Application for Removal or Variation of a Condition following Grant of Planning Permission or Listed Building Consent

Proposed alterations, renovations and extensions including dormer windows on south, east and north elevations

22/02094/FUL

DRAWING:
Proposed Elevations

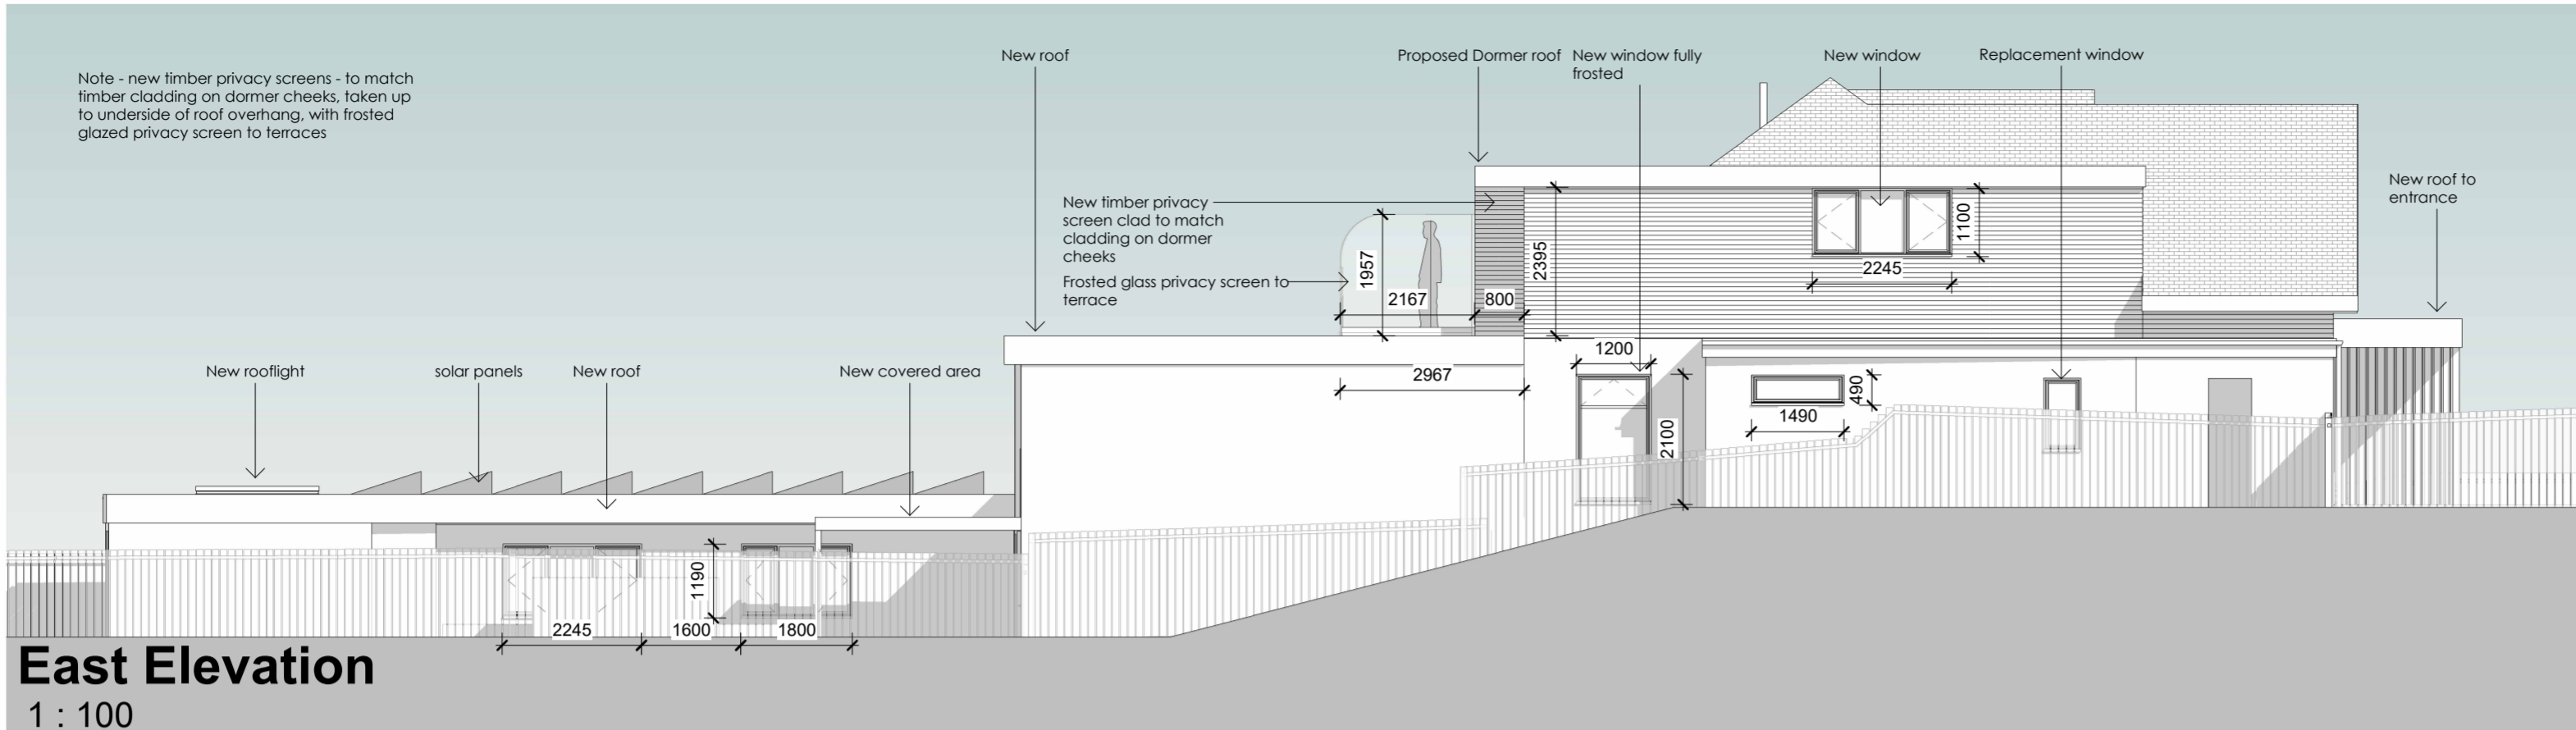
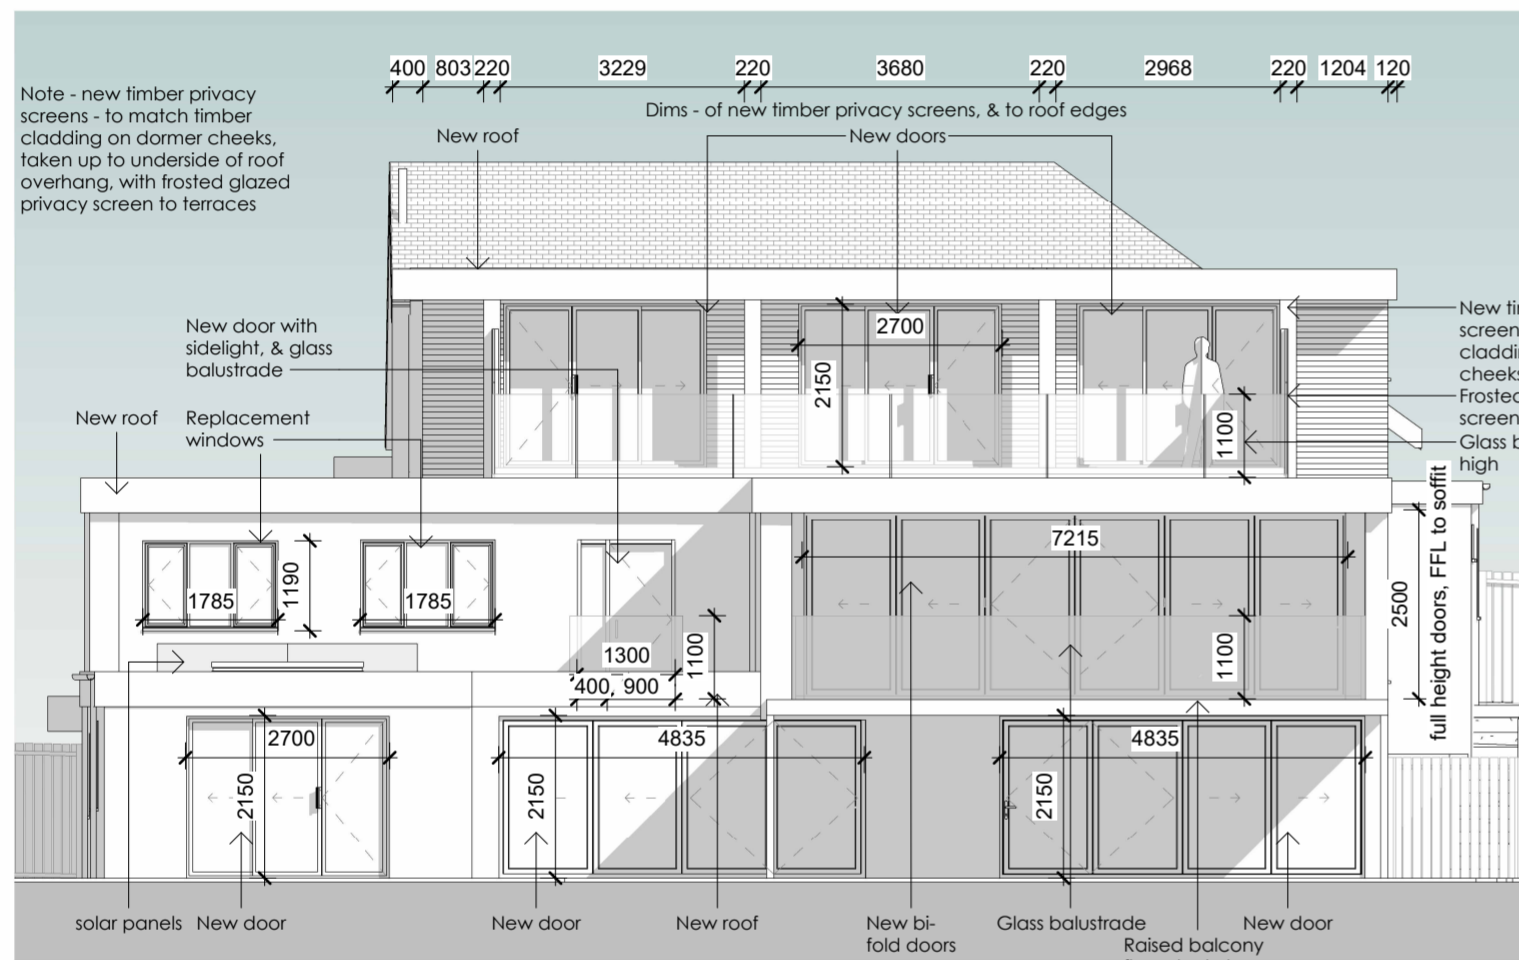
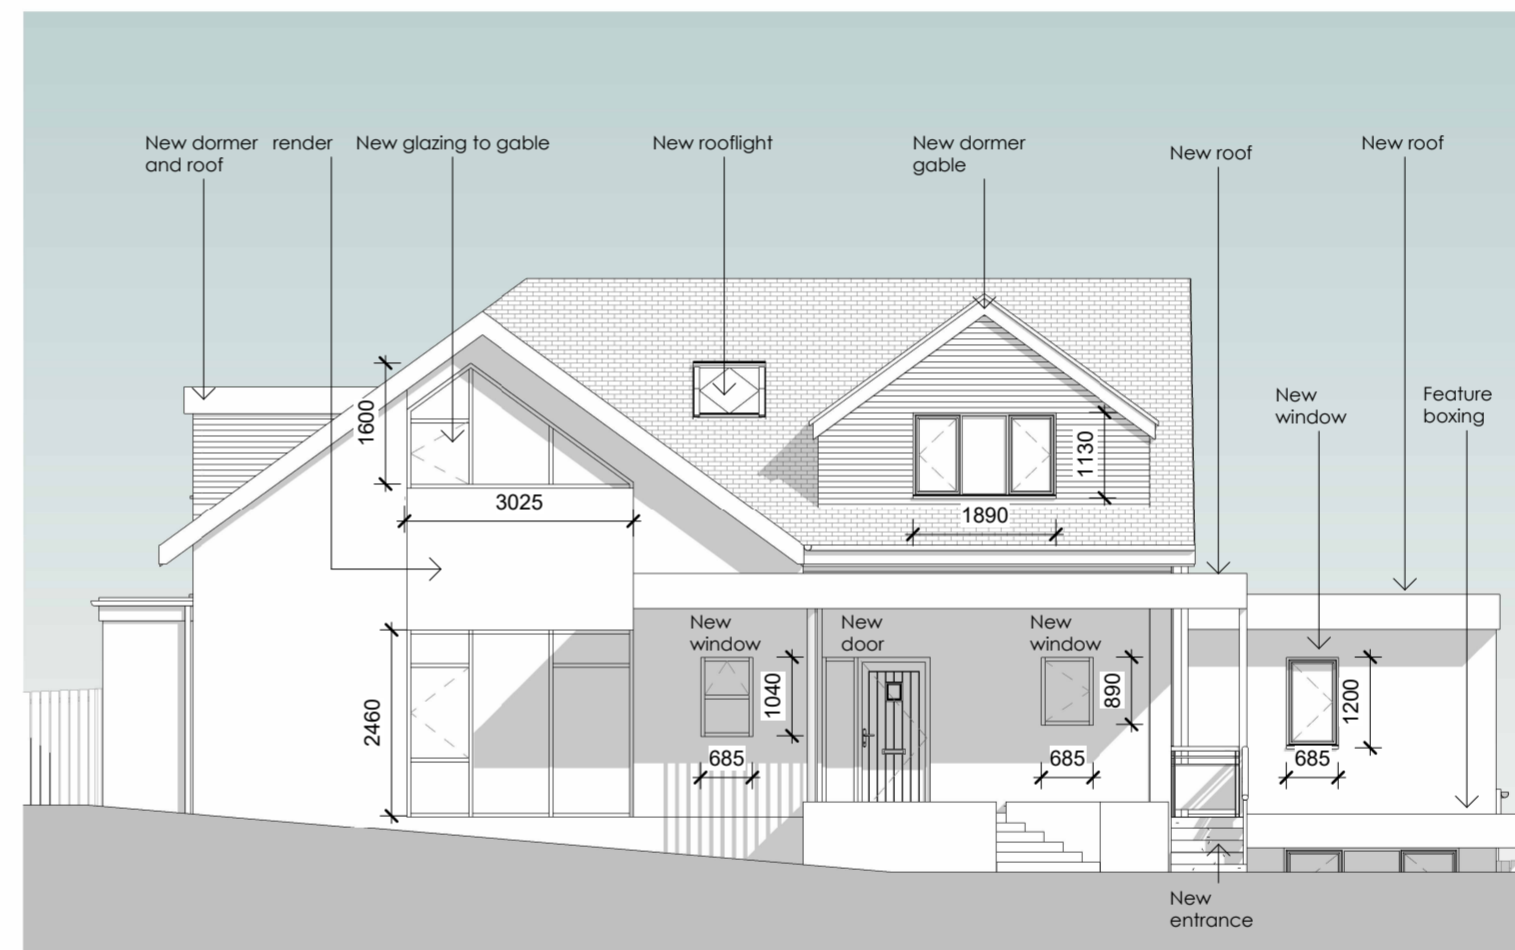
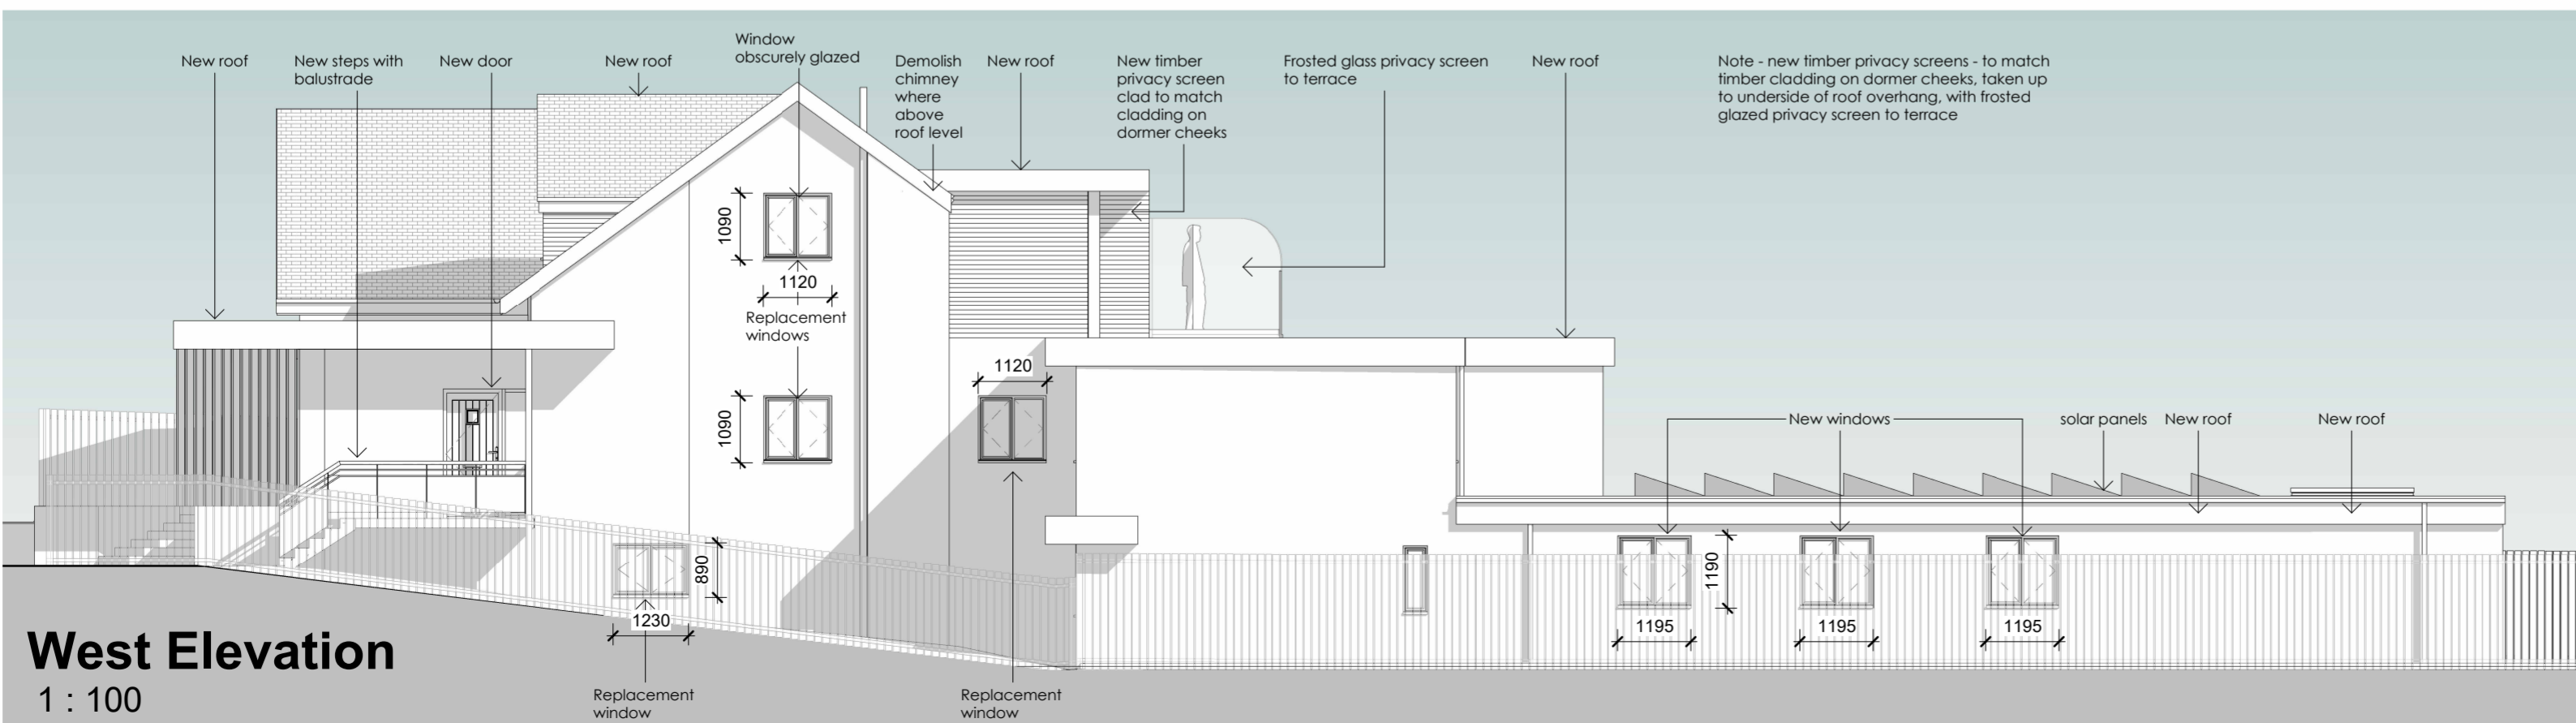
Item 1: It is noted that a glazed exterior door and sidelight has been installed on the ground floor south elevation, instead of a casement window.

Item 2: Patio Bifolding doors have been installed instead of a 3 sash sliding patio doors on the ground floor south elevation.

Please see that the door and side light window measures 1.3m total structural opening width, with a 400mm wide window. This Juliet style balcony is provided with a glazed balustrade so that nobody can access the flat roof, but in the case of an emergency, means of escape can be achieved if a fire occurs to comply with Building Regulations.

Item 2: Patio Bifolding doors have been installed instead of a 3 sash sliding patio doors on the ground floor south elevation.
The bi-fold doors measure 7.2m x 2.26m with x6 bi-fold doors centrally opening.
